One Earth Solar Farm

**Draft Statement of Common Ground with Newark and
Sherwood District Council**

EN010159/APP/8.6.2

October 2025

Drawing Number:  
EN010159/APP/6.20/10.1

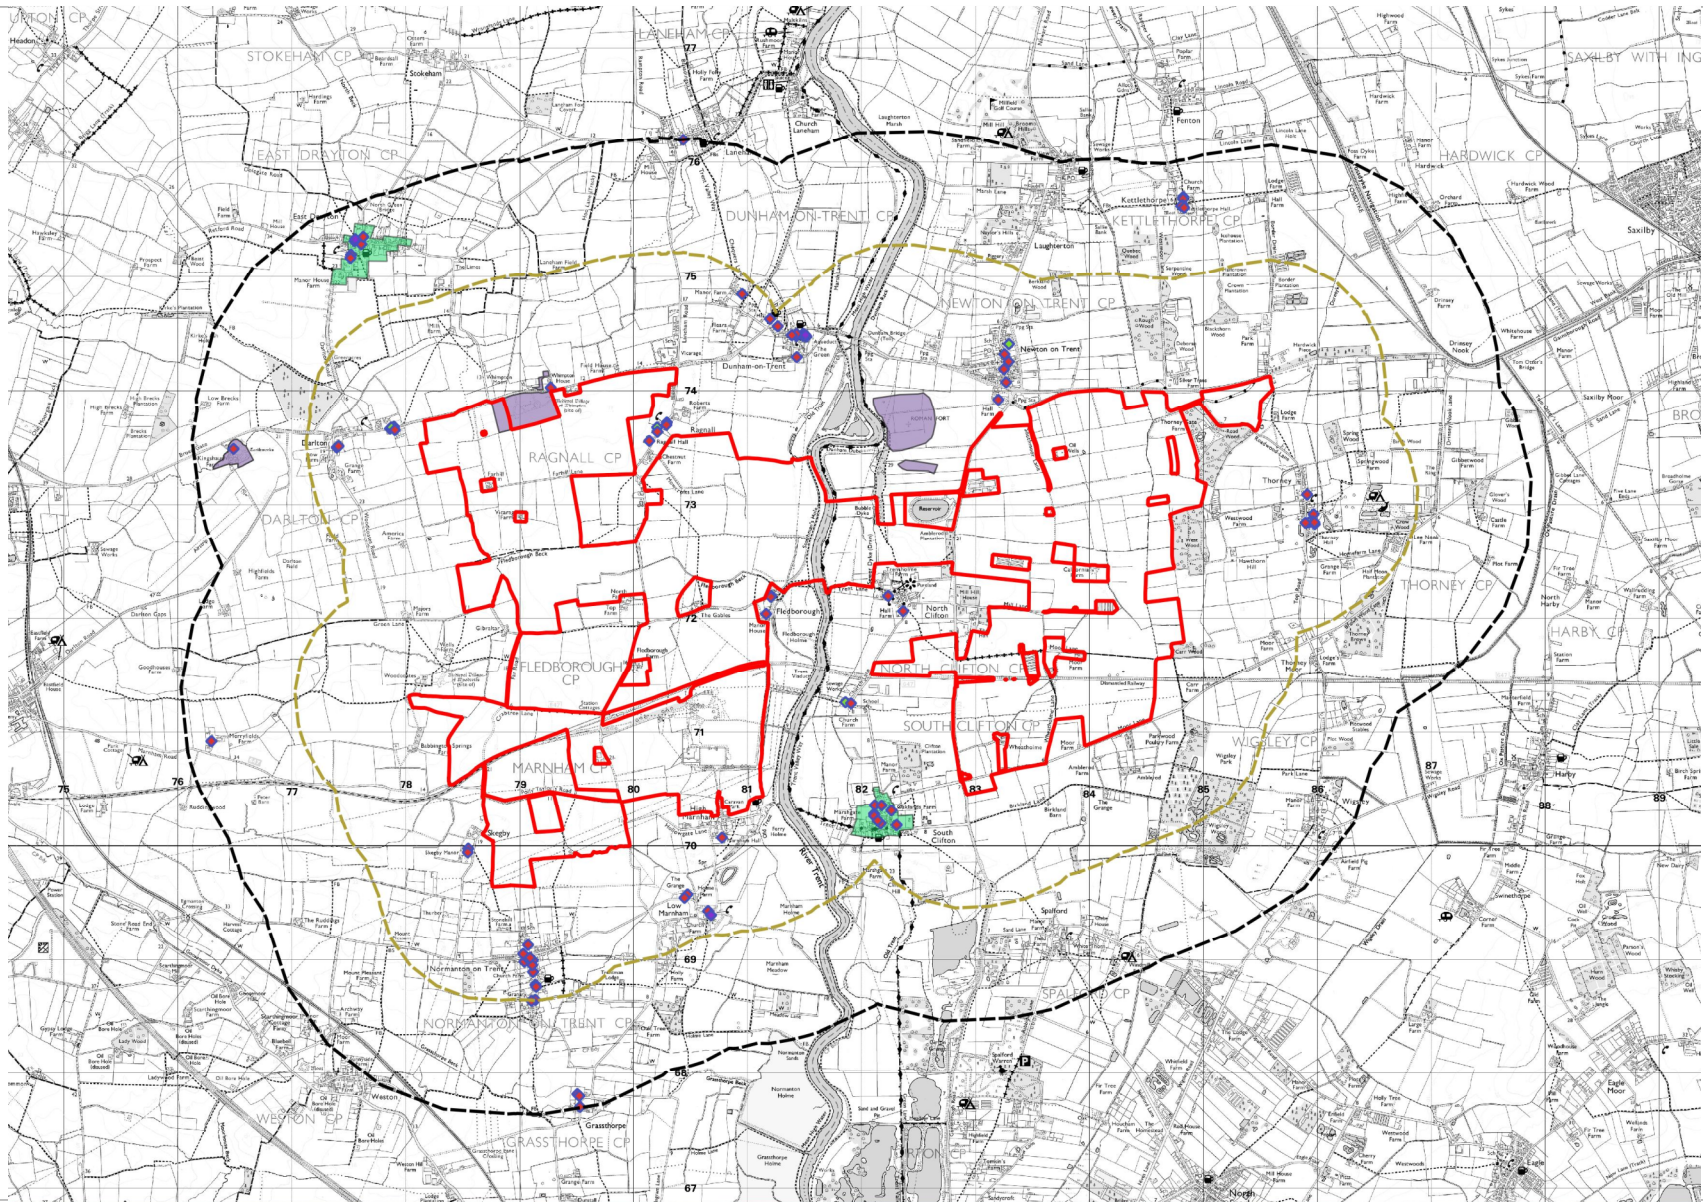
Further detail can be found in the Applicant's Response to Relevant Representations [REP1-075]	
02-08	Firs Farmhouse (Grade II)	Small strip of the solar farm seems encroach towards the heritage asset	Figure 10.1 [APP-055] of ES Chapter 10 [APP-039] confirms that the Order Limits stand at c.930m to the west of this asset. There is no stretch of the Order Limits which stand within the vicinity of the asset and no harm will arise. Further detail can be found in the Applicant's Response to Relevant Representations [REP1-075]	Agreed
02-09	Hall Farmhouse (North Clifton. Grade II, NHLE: 1302529)	There may be possible views from this heritage asset.	As illustrated within Viewpoint 25a (Figure 11.13.7 ^a [APP-068]) and assessed at paragraph 10.6.96 of ES Chapter 10 (ref. APP-039), the Order Limits would stand distant from the asset and hold no intervisibility.	Agreed
02-10	Trent Lane Farmhouse (North Clifton. Grade II, NHLE: 1369937)	There will be views in nearby field. Recommended mitigation suggest increased hedging to the south of the heritage asset.	The Order Limits would stand at distance from the asset (over 280m to the north), would not backdrop views of this asset from the Viaduct, and would hold no adverse effect on the appreciation of the asset as an agriculture farmhouse.	Agreed

Drawing Number:  
EN010159/APP/6.20/10.2

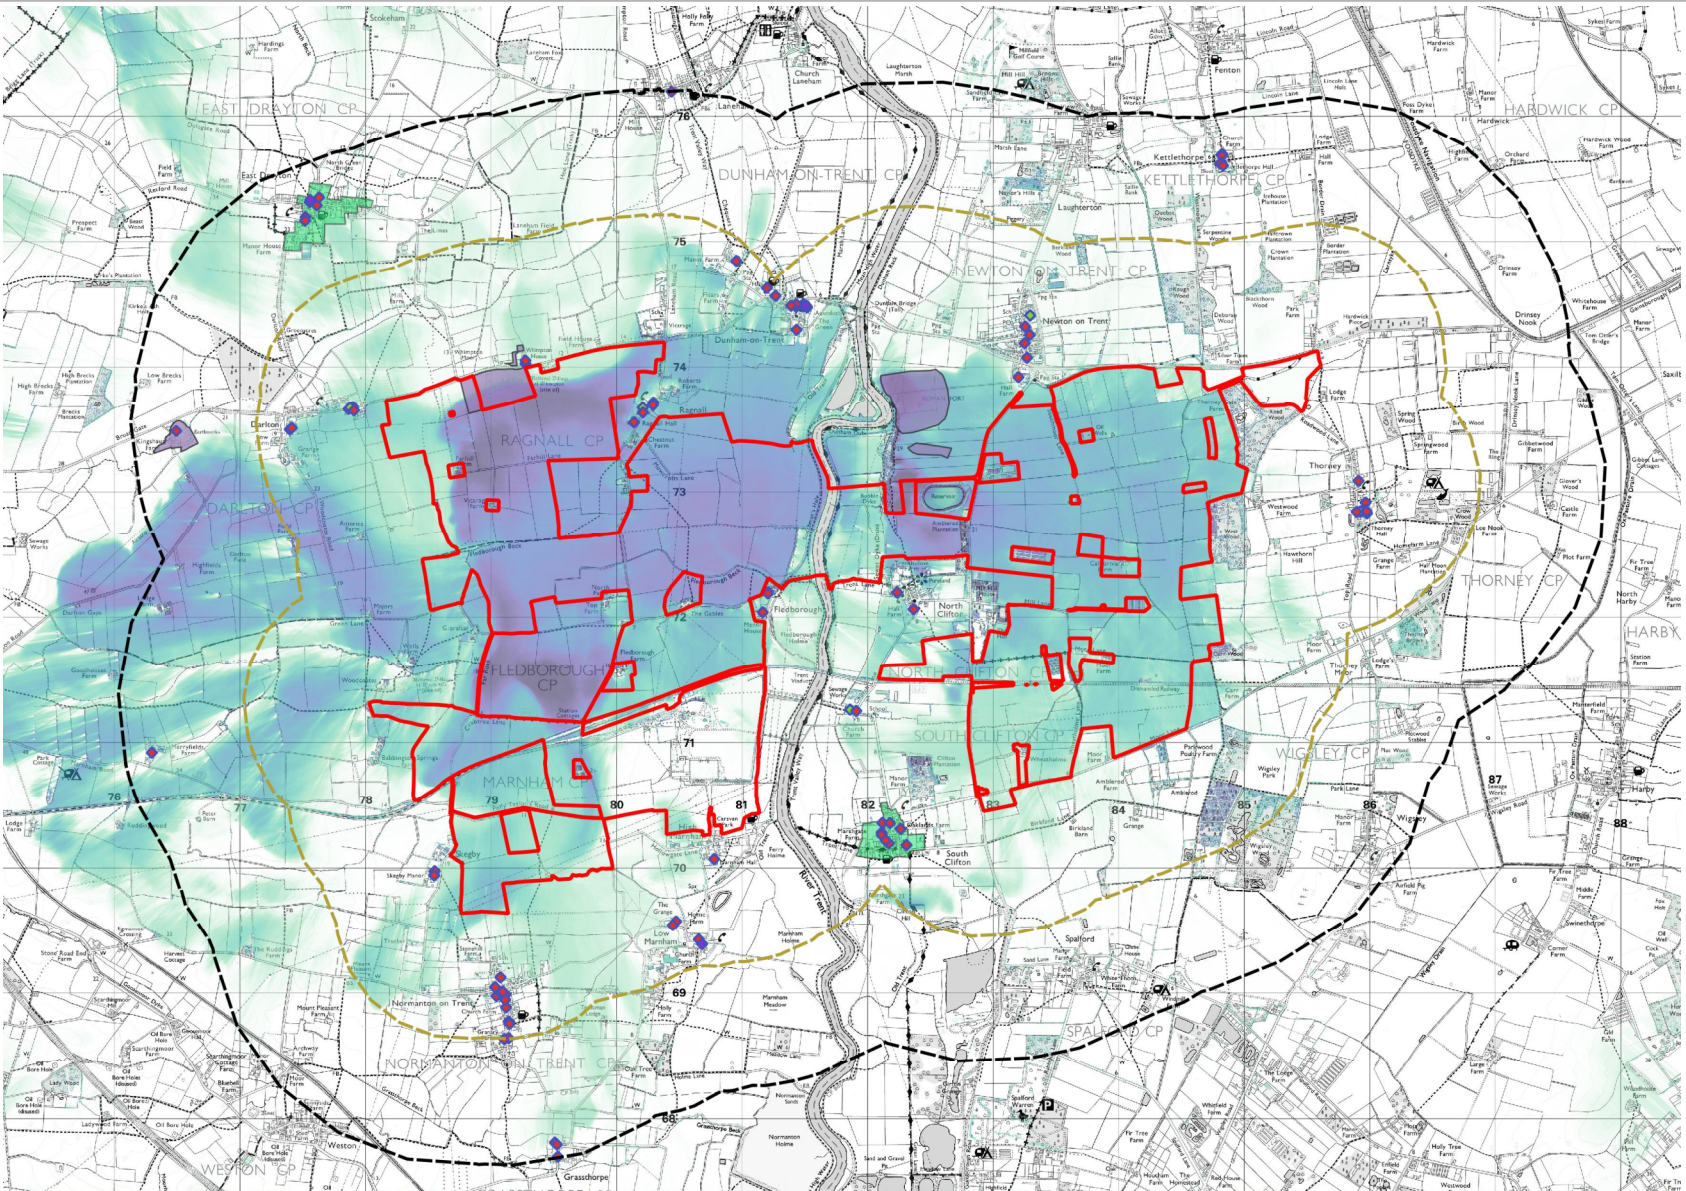
02-04	Perceived impact to Church of St George the Martyr and Church of St Helen	Further consideration required on setting of both assets and further mitigation required – specifically for the impact on Church of St George the Martyr, and Church of St Helen.	<u>Church of St George the Martyr</u> Effects of the Proposed Development on St George the Martyr are located within paragraphs 4.136 – 4.139, page 66 of Technical Appendix 10.3 [APP-128] and paragraphs 10.9.9 and 10.6.98.100 of ES Chapter 10 [APP-039]. <u>St Helen Church</u> This asset has been assessed in ES Chapter 10 (ref. APP-039) at paragraphs 10.6.7 and	Agreed

10.6.126, in paragraph 4.191 of the Technical Appendix [APP-128]. The Zone of Theoretical Visibility mapping [Figure 10.3 (APP-055)], the Proposed Development would hold no visibility. Further detail can be found in the Applicant's Response to Relevant Representations [REP1-075]	
02-05	Ruins of Old Church in Churchyard	Recommendation of further mitigation to protect any views.	This asset has been assessed in ES Chapter 10 (ref. APP-039) at paragraphs 10.6.7 and 10.6.126 and on page 85 of Appendix 10.2 (grouped with other assets in Thorney, as agreed with stakeholders – see Table 10.5 [APP-128]). The Zone of Theoretical Visibility, there would be no impact to the value (significance) of this asset, further mitigation is not required as no harm can feasibly exist which requires screening. Further detail can be found in the Applicant's Response to Relevant Representations [REP1-075]	Agreed
